December 8, 1999

**RE: HEALTHCARE FOR THE HOMELESS(J14-D132).. ENGINEER'S
CERTIFICATION FOR CERTIFICATE OF OCCUPANCY APPROVAL.
ENGINEER'S STAMP DATED OCTOBER 1, 1999.**

February 4, 1999

**RE: DRAINAGE REPORT FOR HEALTHCARE FOR THE HOMELESS (J-14/D132)
RECEIVED JAN 4, 1999 FOR BUILDING PERMIT
ENGINEER'S STAMP DATED 12/31/98**

AS-BUILT

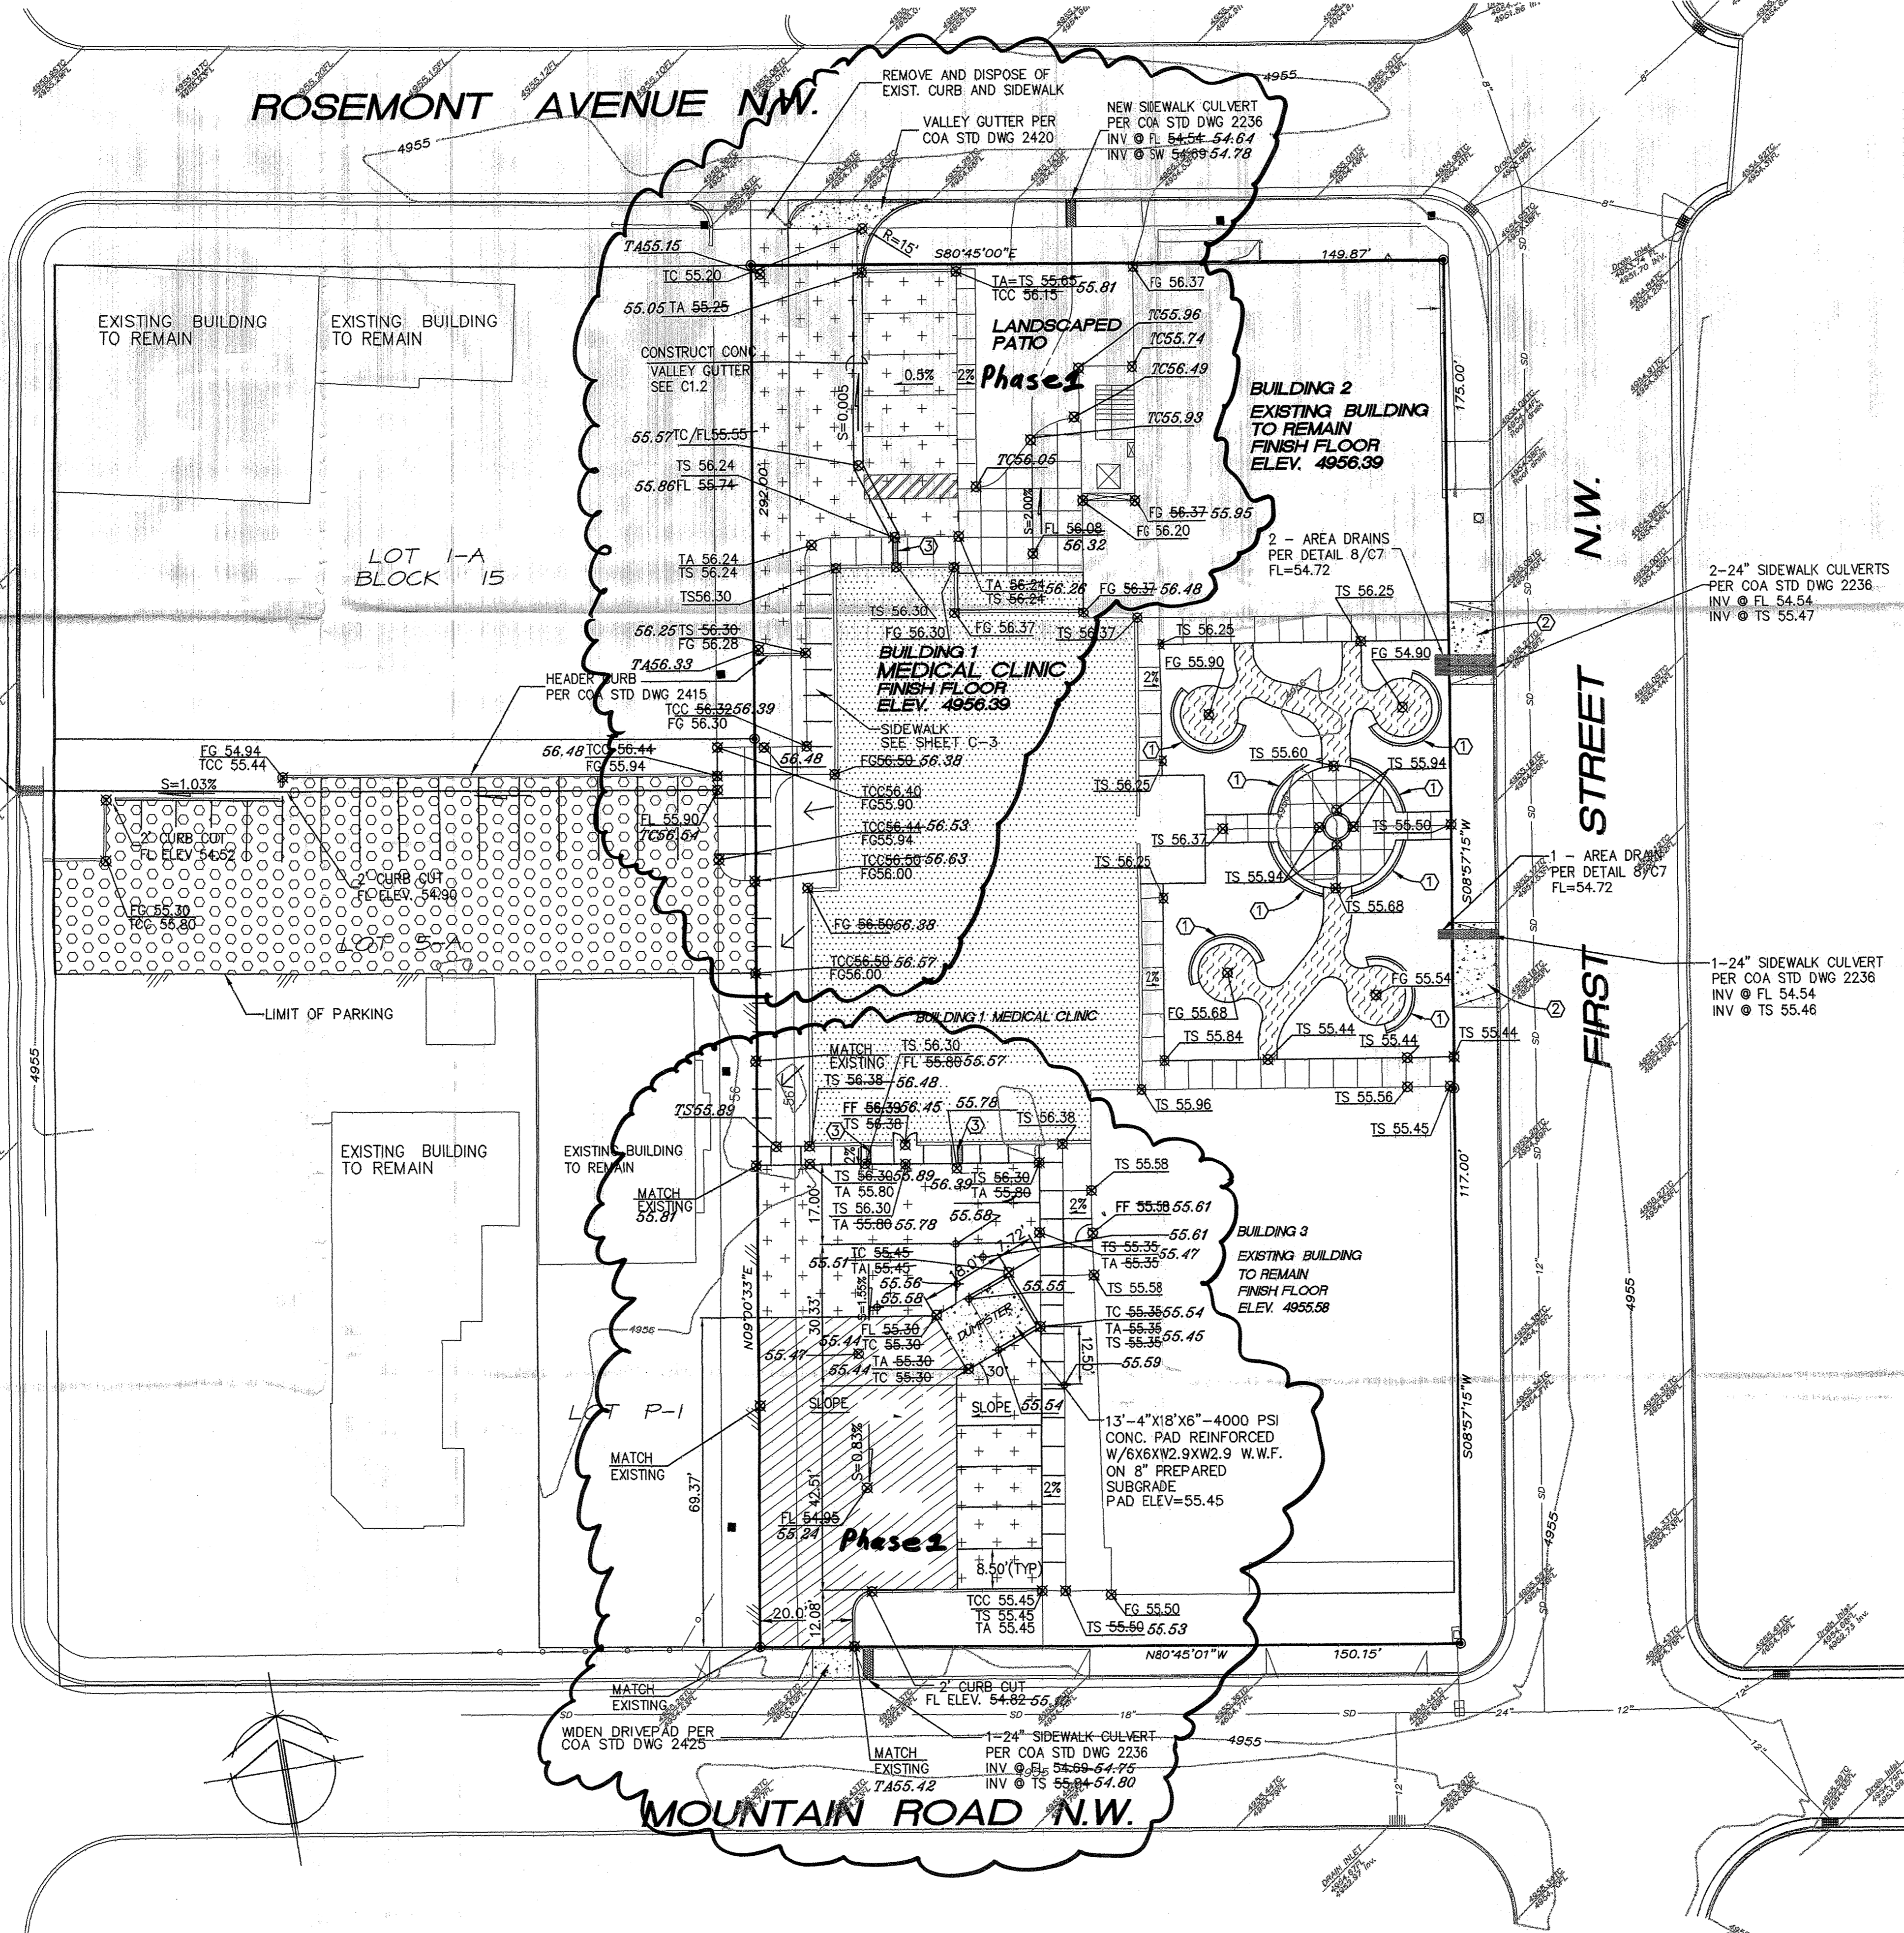
For the record, the File Copy of the G&D Plan should have both the 12/31/98 Engineer's Stamp Date and executed SO#19 Signature Block. It is clear that the 10/1/99 Engineer's Certification is for the 12/31/98 Plan.

SHEET
C-5
OF

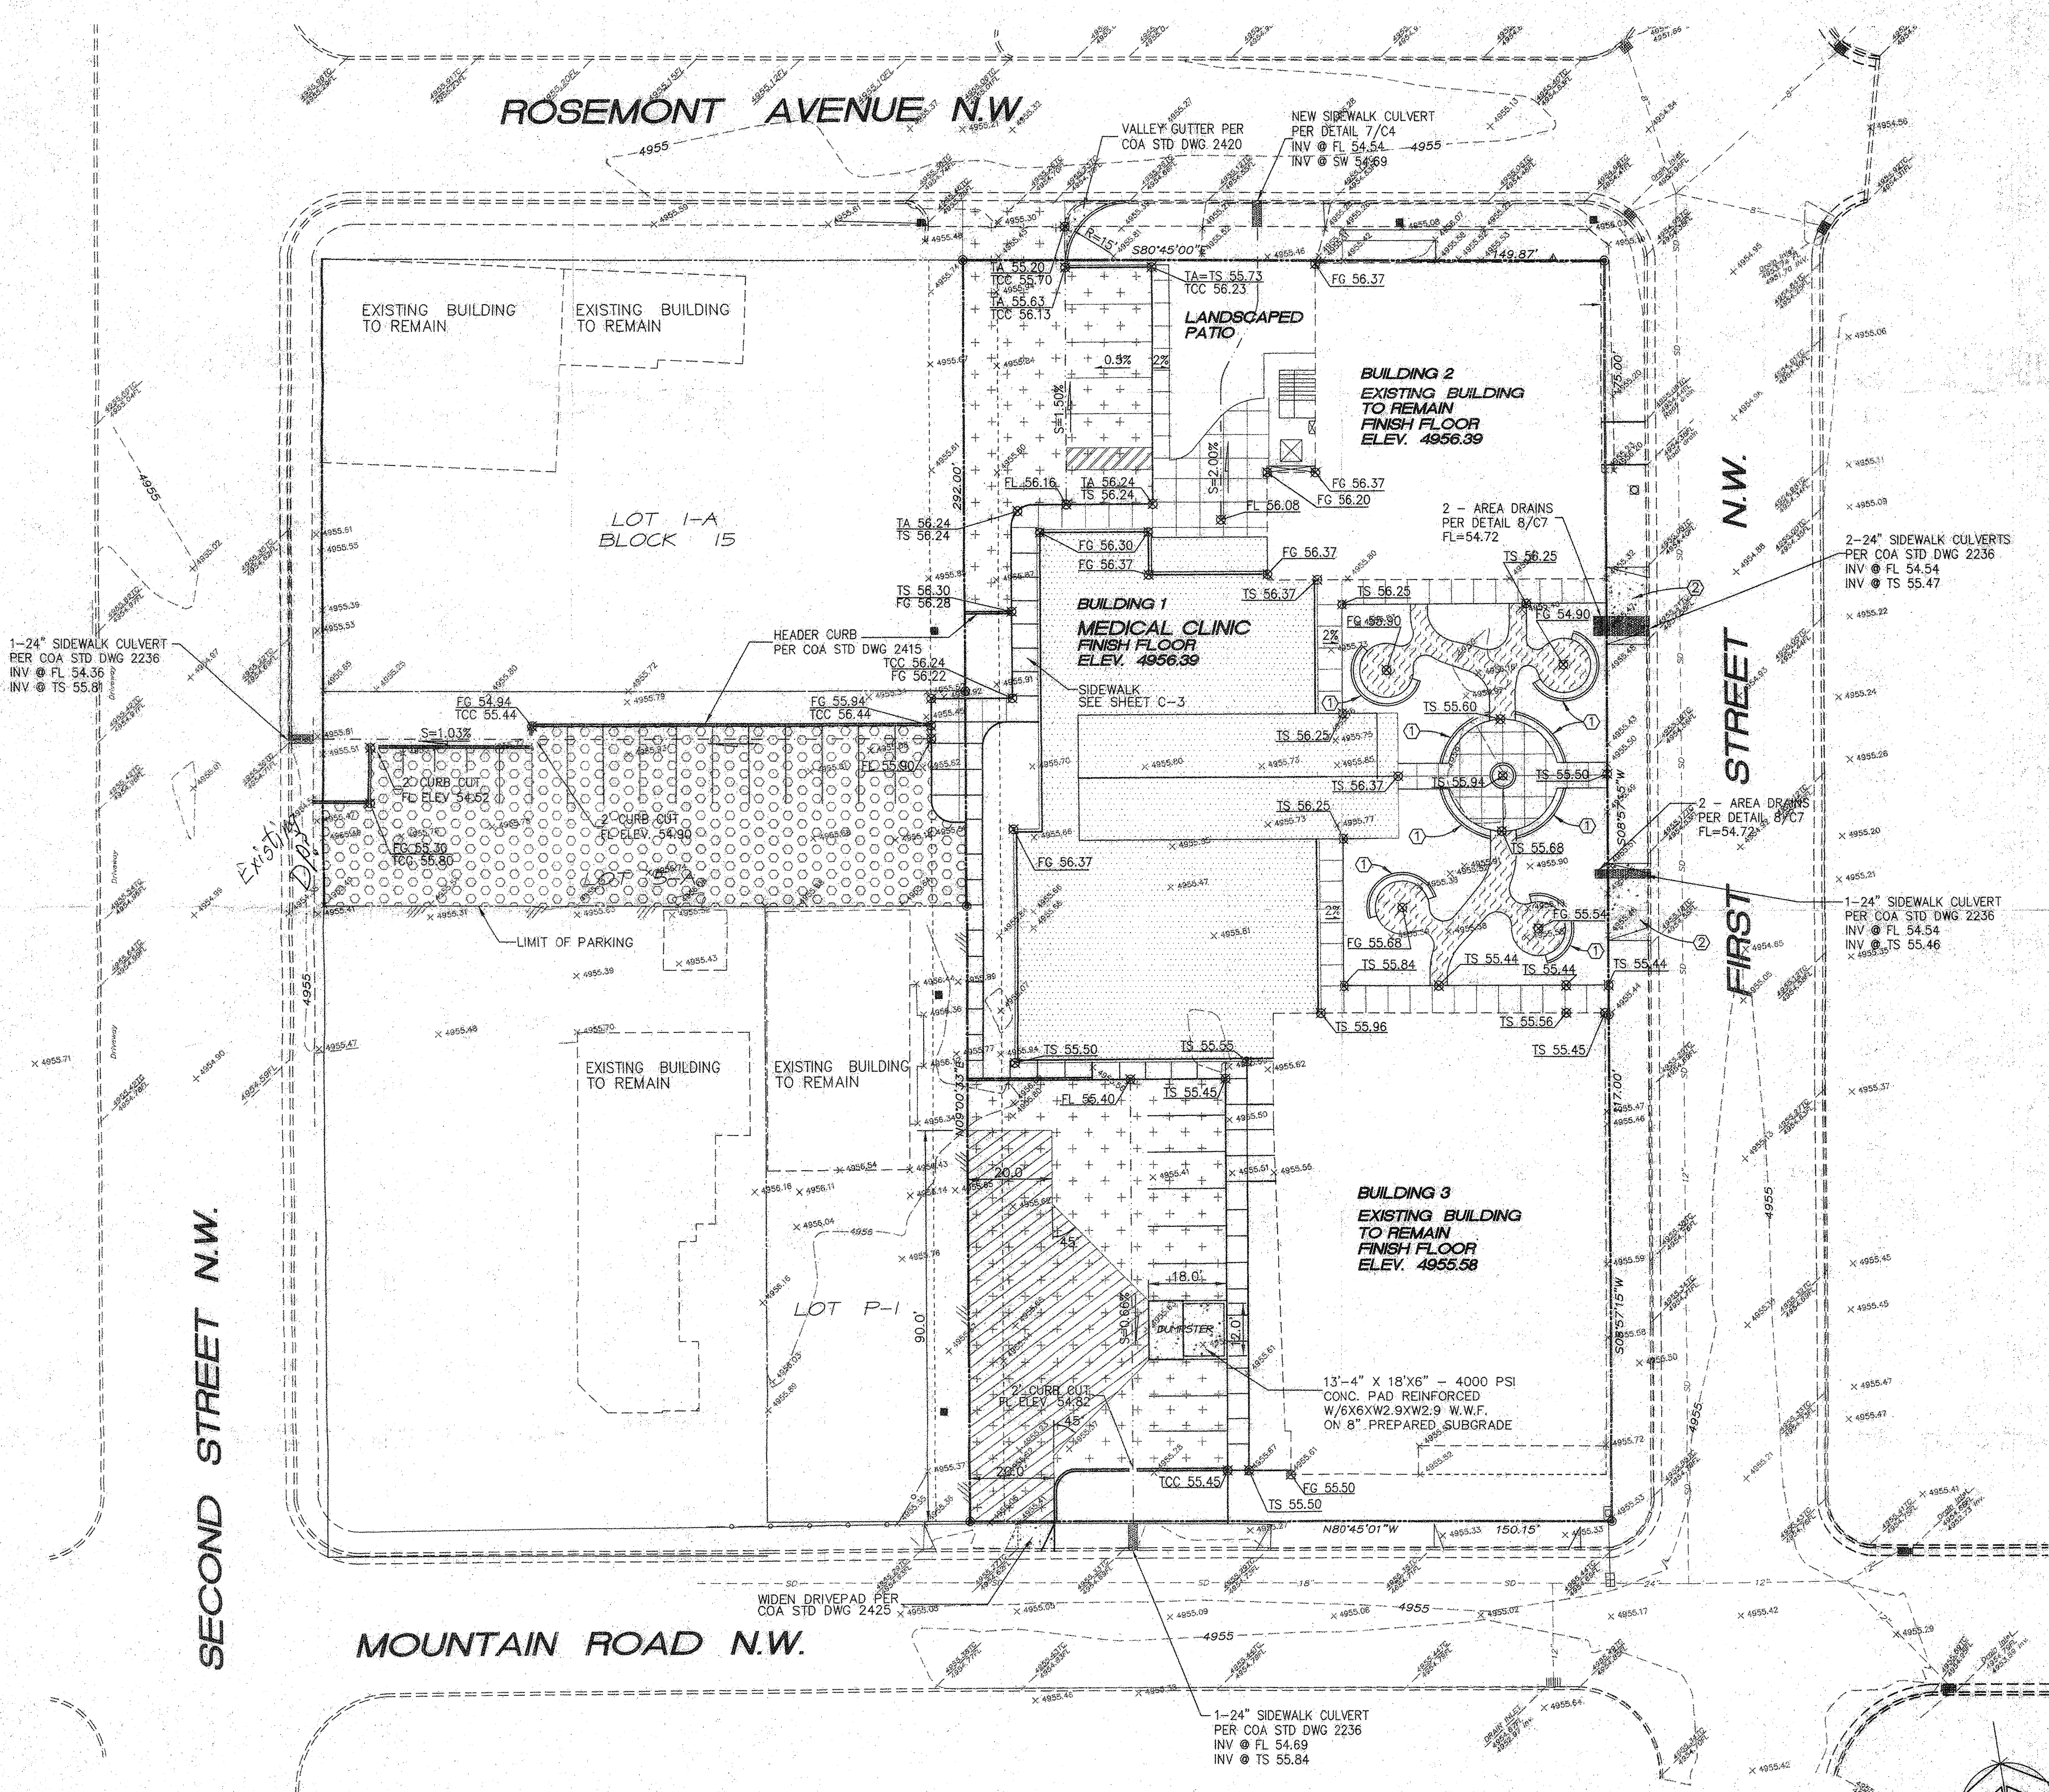
Based on the information included in the submittal referenced above, City Hydrology accepts the Drainage Report for Building Permit. Make sure the **north arrow, scale and existing drivepad** on 2nd Street are shown on Sheet C-5. Include a copy of the approved
